Minsmere Levels Stakeholders Group Open Floor Hearing Transcript

Minsmere Levels Stakeholders Group main areas of concern regarding the Sizewell C development proposal are as follows. The Hard and Soft Coastal Defence, the Permanent and Temporary Beach Landing Facilities and impacts on the inland hydrology of both Sizewell Marsh and Minsmere South Levels as a result of the loss of Sizewell Marsh SSSI land, redirection of the Sizewell Drain, the SSSI Crossing and impacts of the borrow pits and spoil heaps.

SECTION @ B - B - SEA DEFENCE
SCALE 1:250

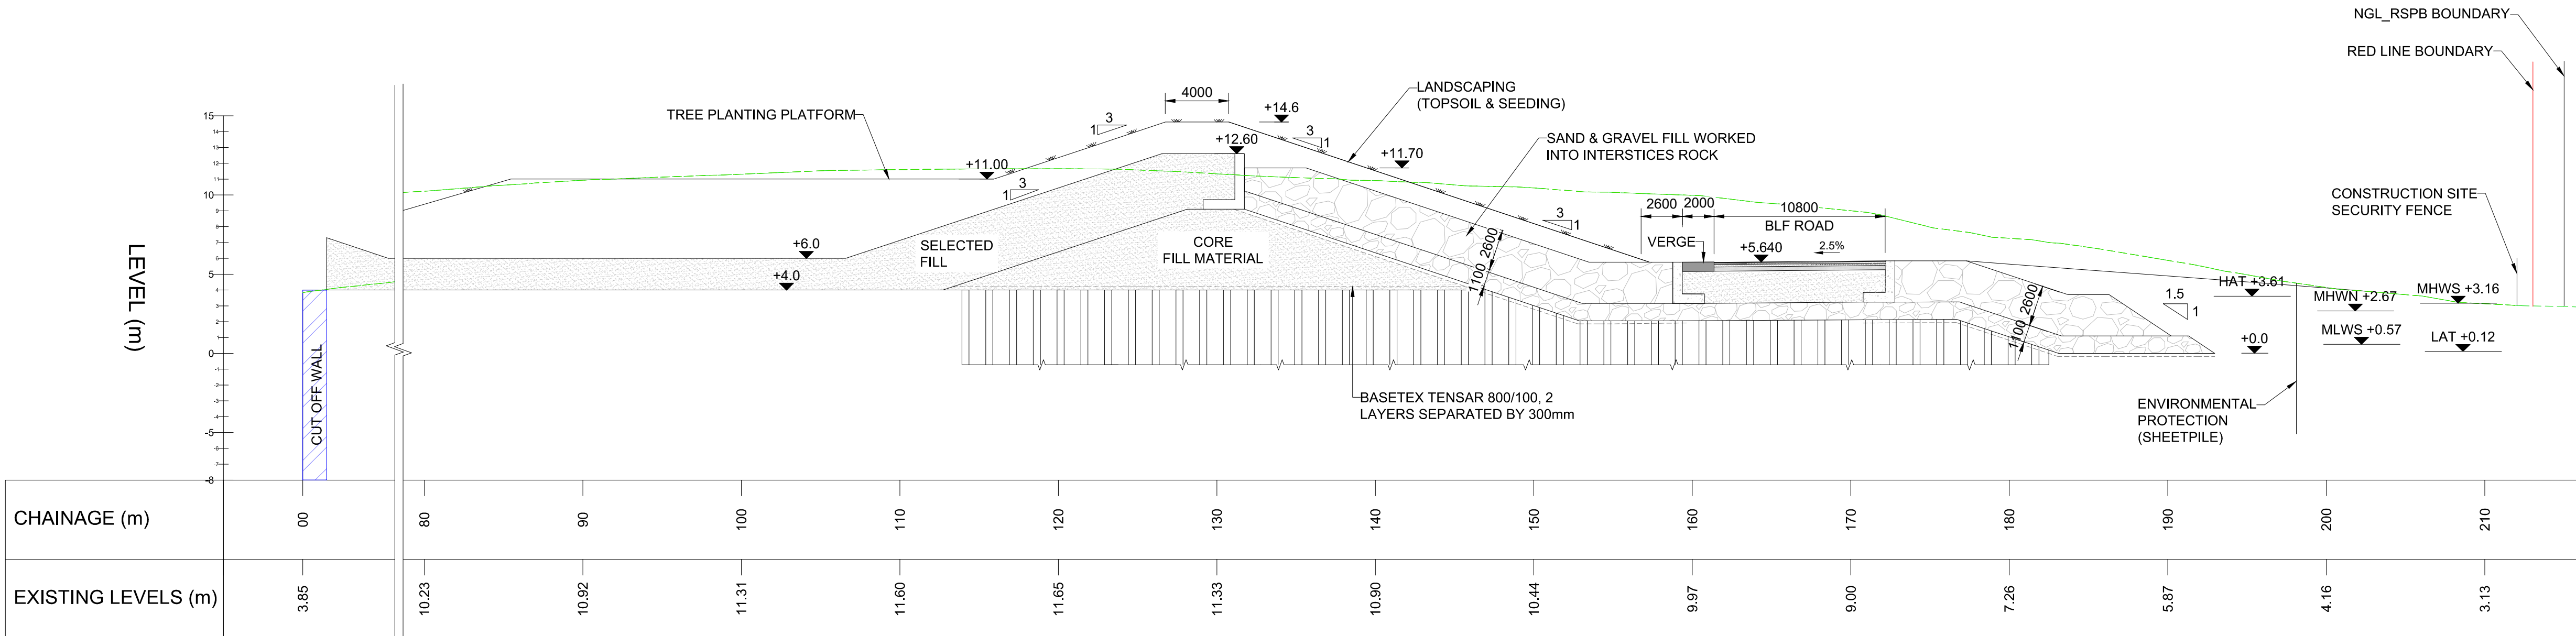
However, the three cross sections provided do not indicate where within the frontage these are located and there are inconsistencies between the figures with no consistent reference points to the cut-off wall, which is also the border between parameter zones C1 (cut-off wall) and C21 (HCDF/SCDF) ([AS-118](#)). One of the figures has no room to allow the adaptation increase in height of the HCDF and there is an inconsistency between figures regarding the toe of the adapted HCDF and statement 2.2.194 in the Environmental Statement Addendum ([AS-181](#)).

Whilst we await the detailed plans for the HCDF/SCDF at Deadline 2, we are concerned that unless cross-sections are given for the interface with SZB defences, the frontage at several locations and one through the reconstructed northern mound and BLF access roadway, a full evaluation will not be possible.

It is also unclear how the Hard Coastal Defence will incorporate and wrap round the access roadway given the position of the landward end of the BLF access roadway, the removable roadway and the piles and crossbeams progressing towards the barge mooring end of the structure 100m from the coast.

During consultations the slope of rock armour at the end of the permanent roadway was given as 1:4. In the plans referenced above, the roadway is given as being 5.435m AOD this will require about 22m of rock armour to reach 0m OD, the same level as the initial toe of the Hard Coastal Defence. This implies a significant incursion into the beach itself.

DRAWING TITLE:
MAIN DEVELOPMENT SITE
KEY PLAN
RULE 17 REQUEST FOR FURTHER INFORMATION

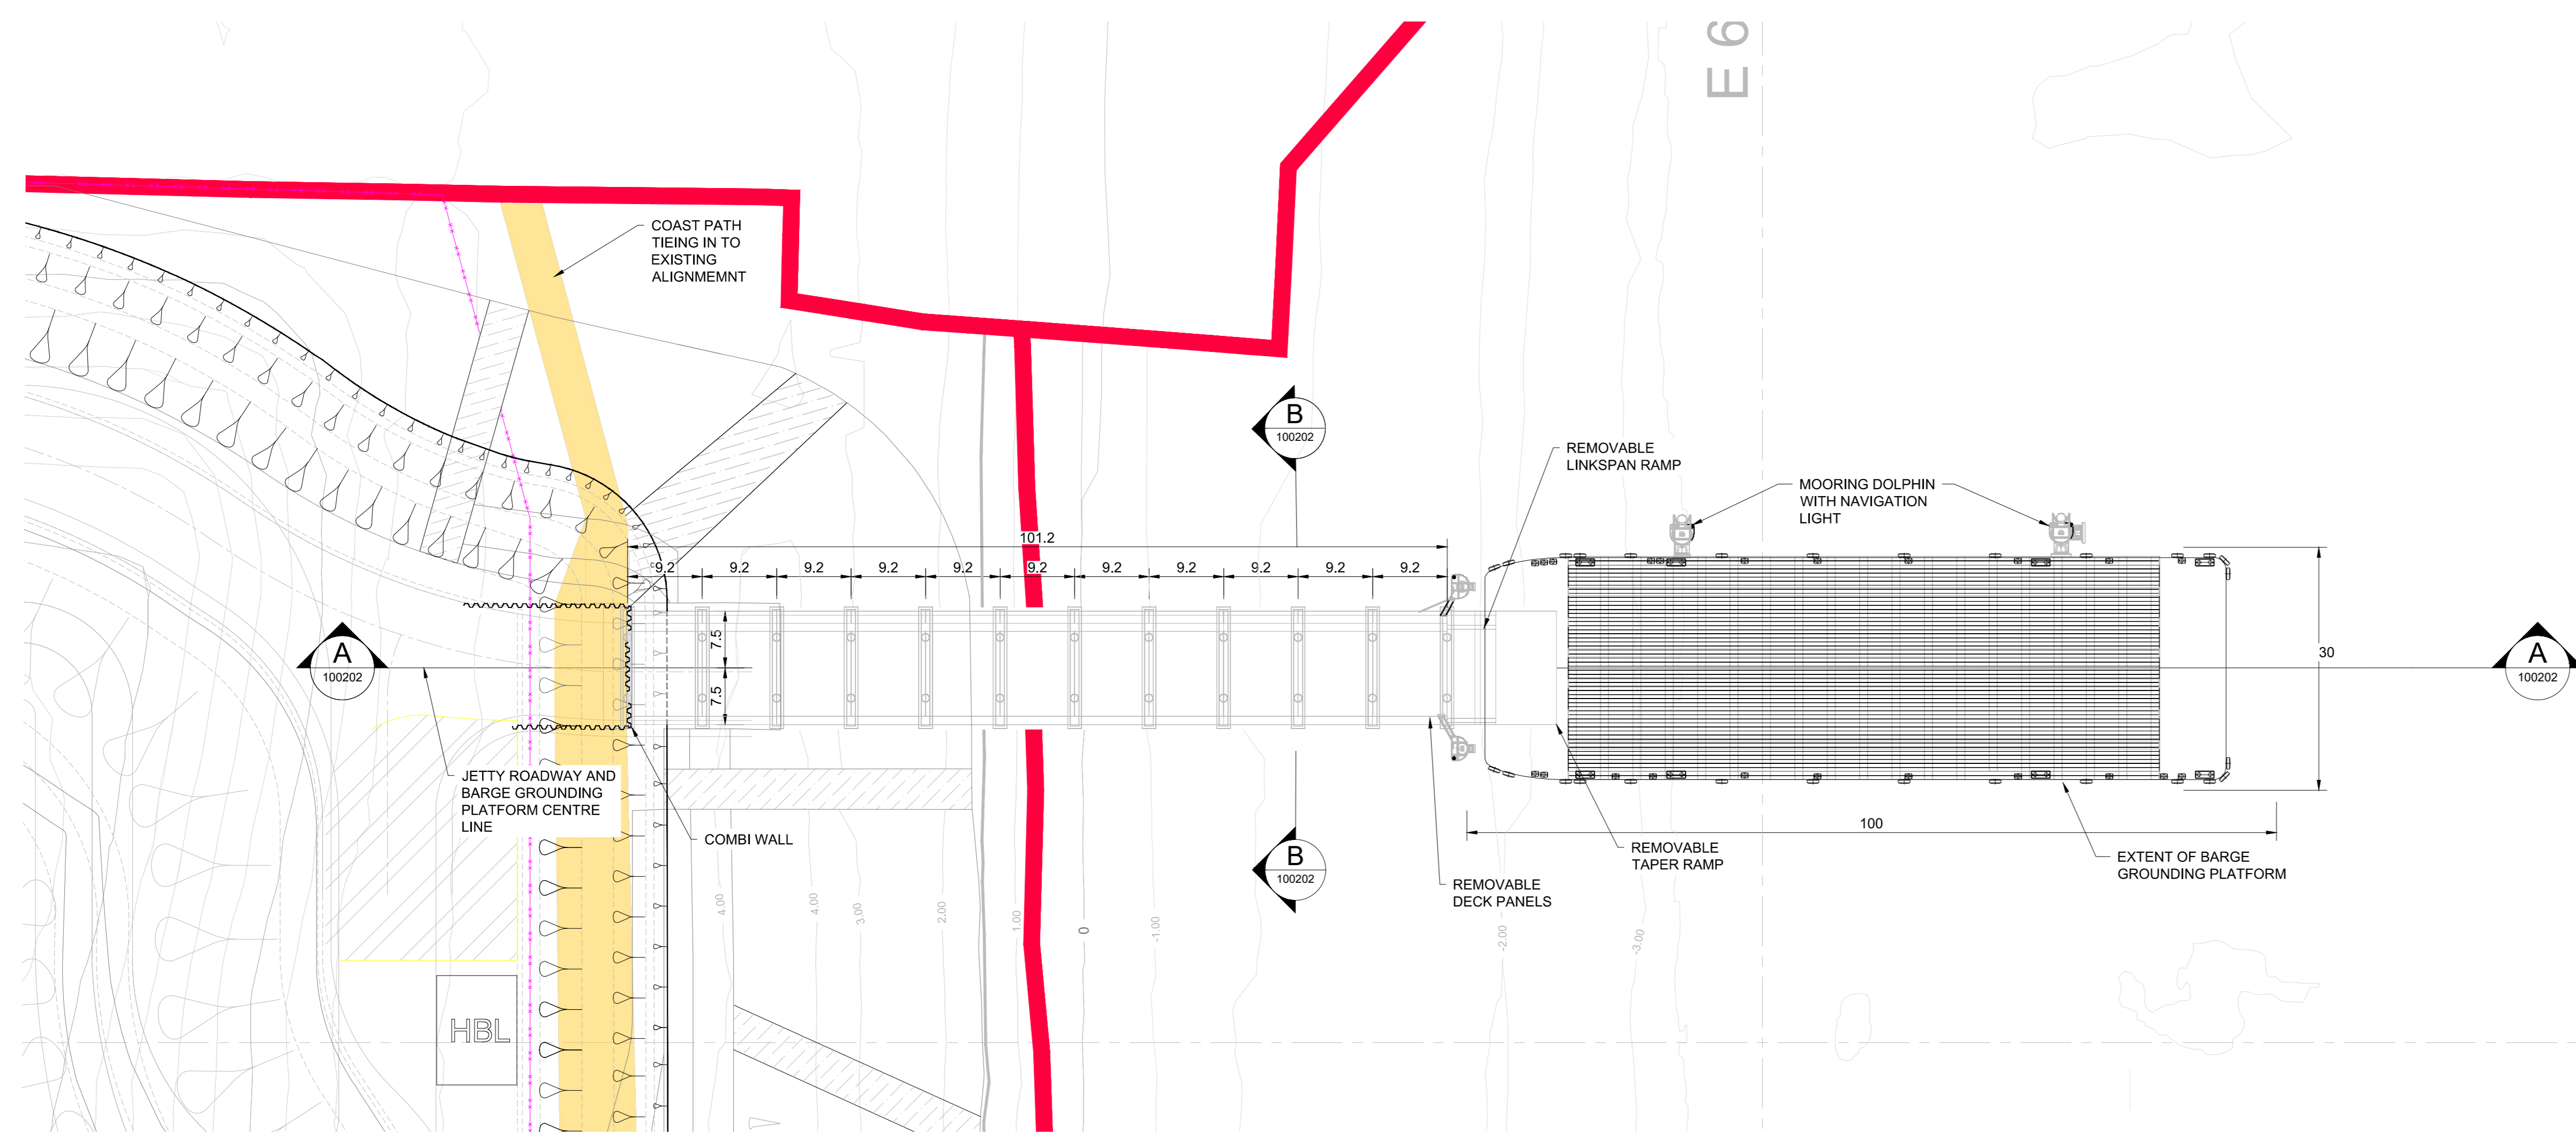
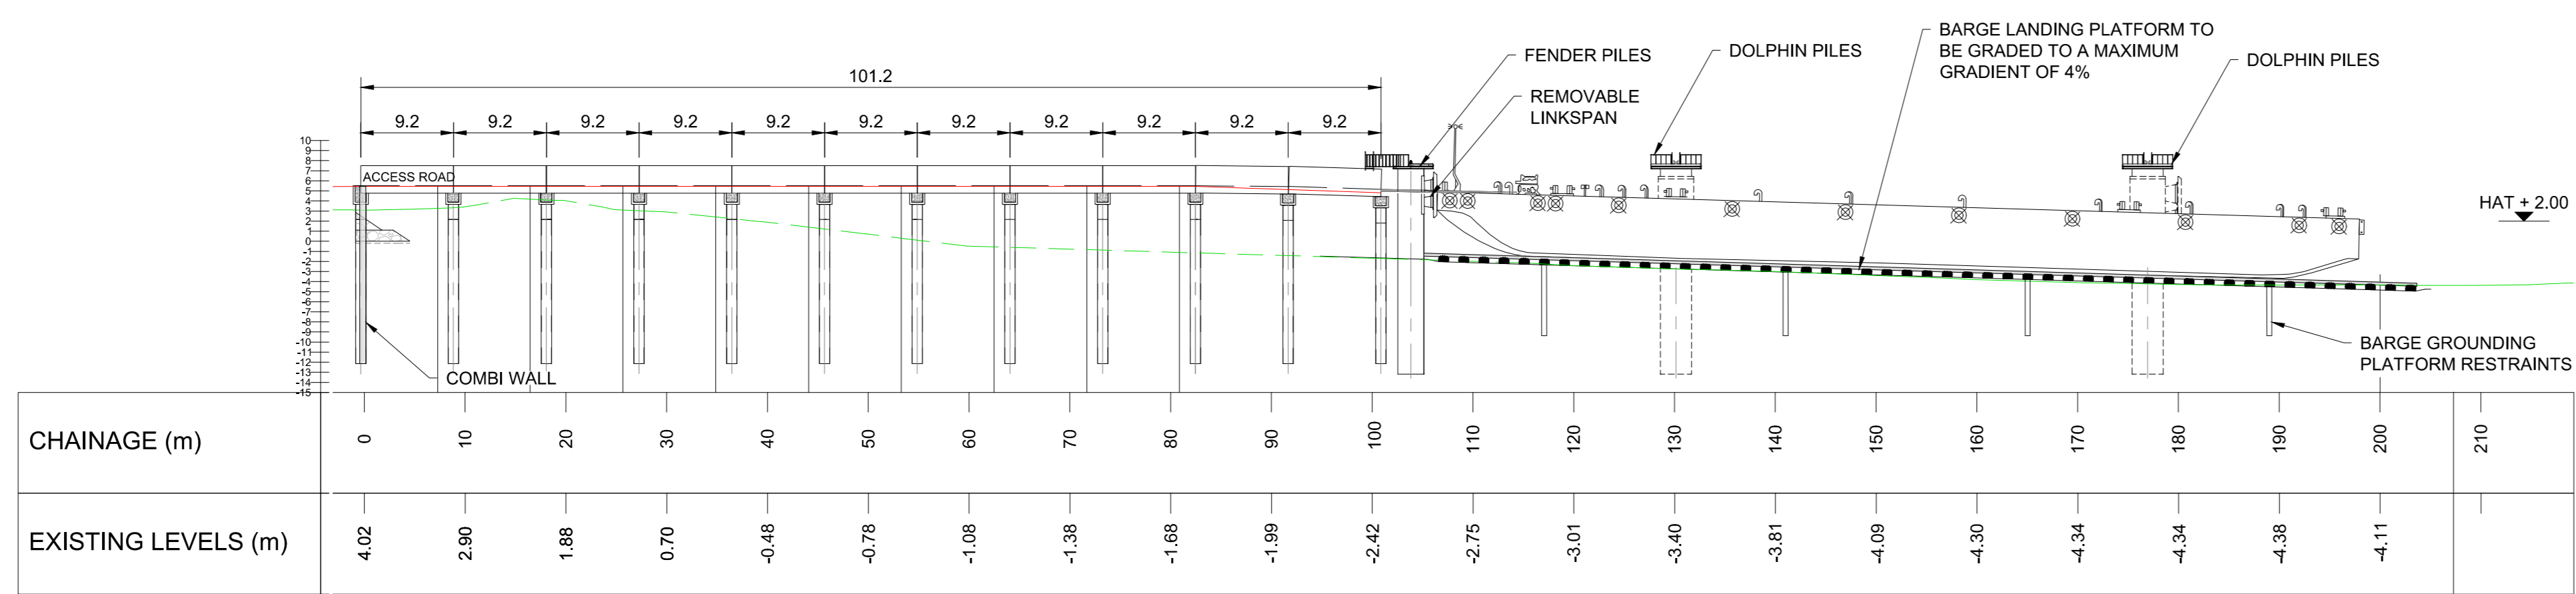
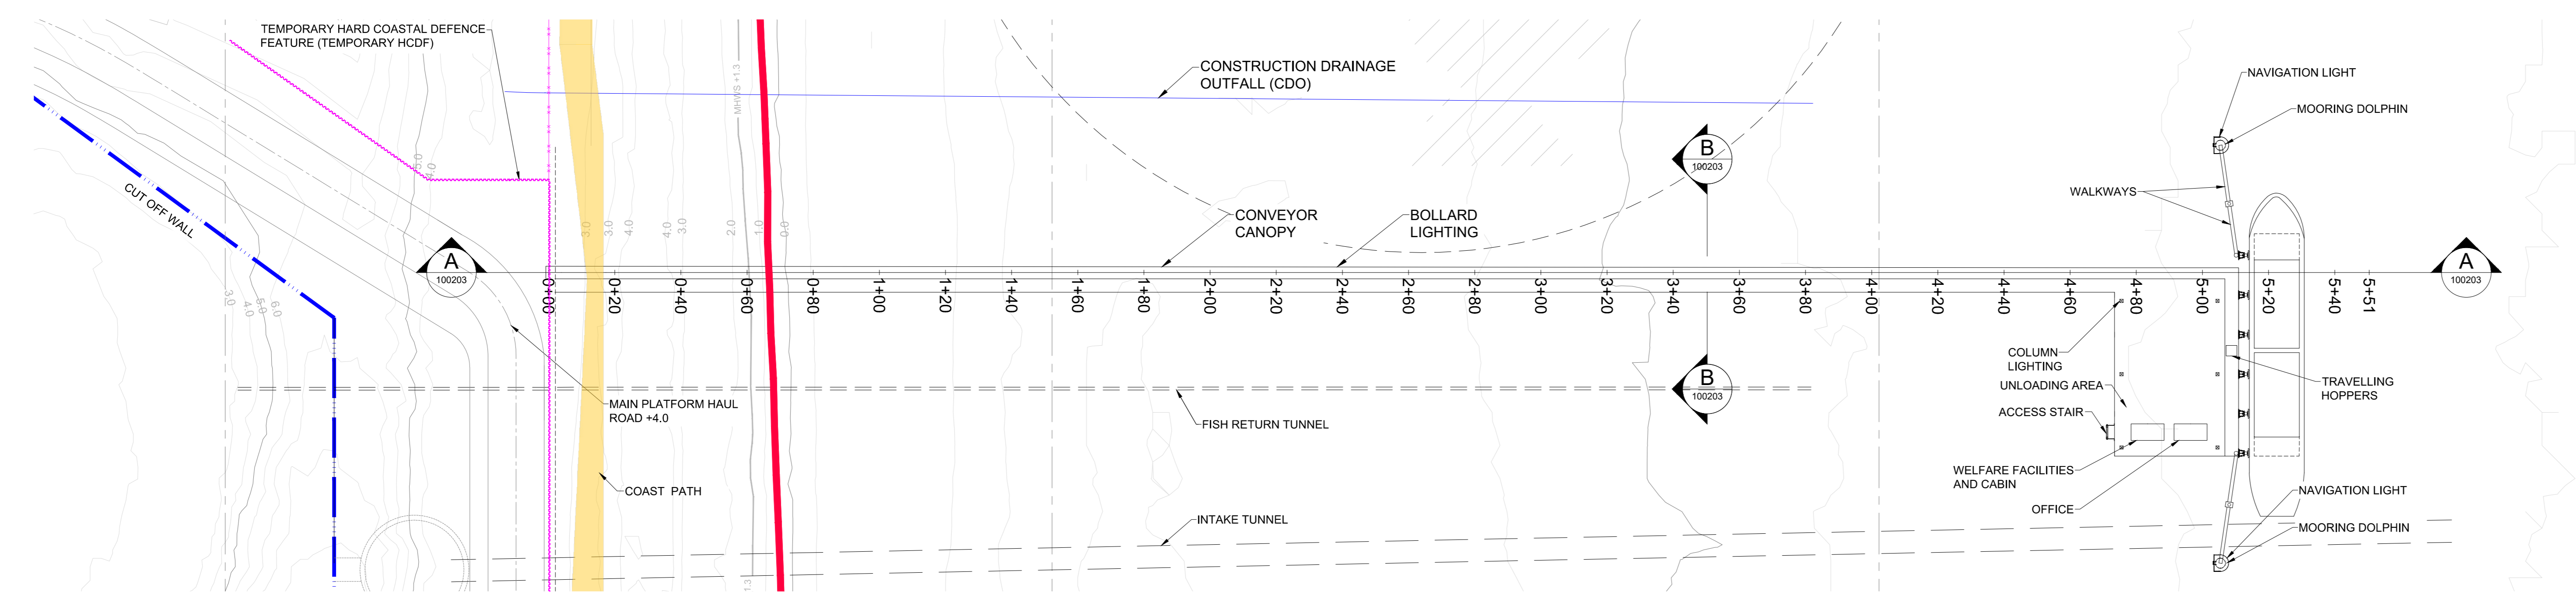
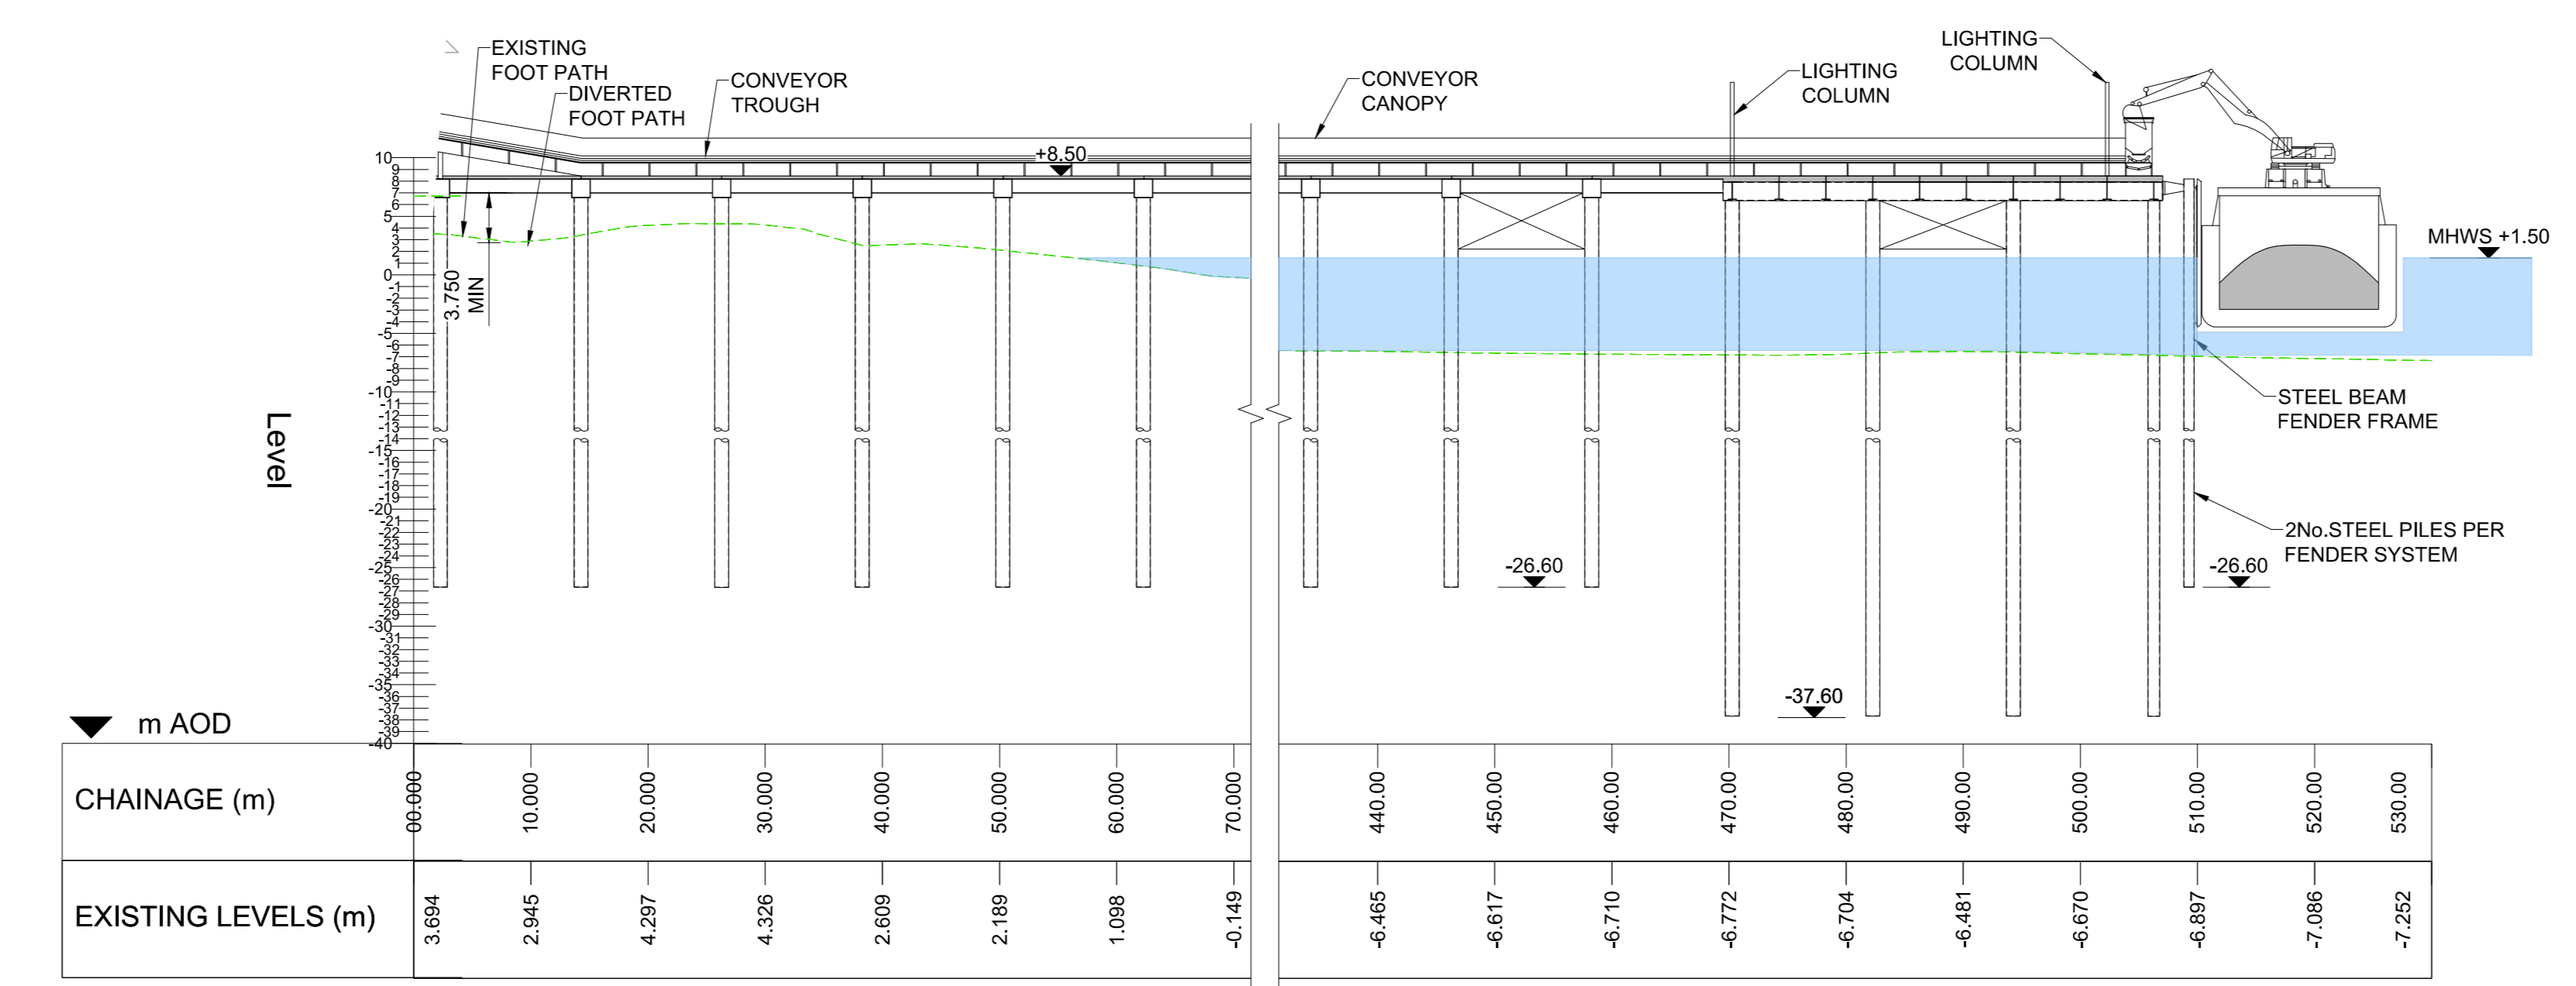
Fourthly: The latest iteration of the SSSI crossing proposes a wider culvert, which still does not provide an open environment for wildlife to transit between Minsmere Southern Levels and the Sizewell Marsh.

There is still effectively a dead zone inside the culvert structure that will be totally dark. The applicant has still not given a valid reason why the three-section bridge structure initially proposed in the earliest consultations, which would allow natural light below the roadway, has been rejected. This despite the fact that Natural England and the Environment Agency and others continue to object to the culvert design.

The SSSI crossing structure, which is piled and surrounded by sheet piling ([PDA-005](#)), will also interfere with the ground and surface water hydrology features of these connected areas. We do not agree with the assessment that the effects will be minor especially given the applicants admission that water levels in the southern Minsmere Levels will be raised, resulting in a flood risk compensation area being created in the southern Minsmere Levels. Modelling results quoted in the updated flood risk assessment ([AS-018](#)) 12.7.4 through 12.7.8 indicates some increase in risk to Minsmere Levels, although a small potential benefit to Sizewell Marsh and on to Leiston as a result of the presence of the SSSI crossing. This implies increased drainage from Sizewell Marsh and interference with the hydrological connection between these two areas. Another consequence of this will be potential
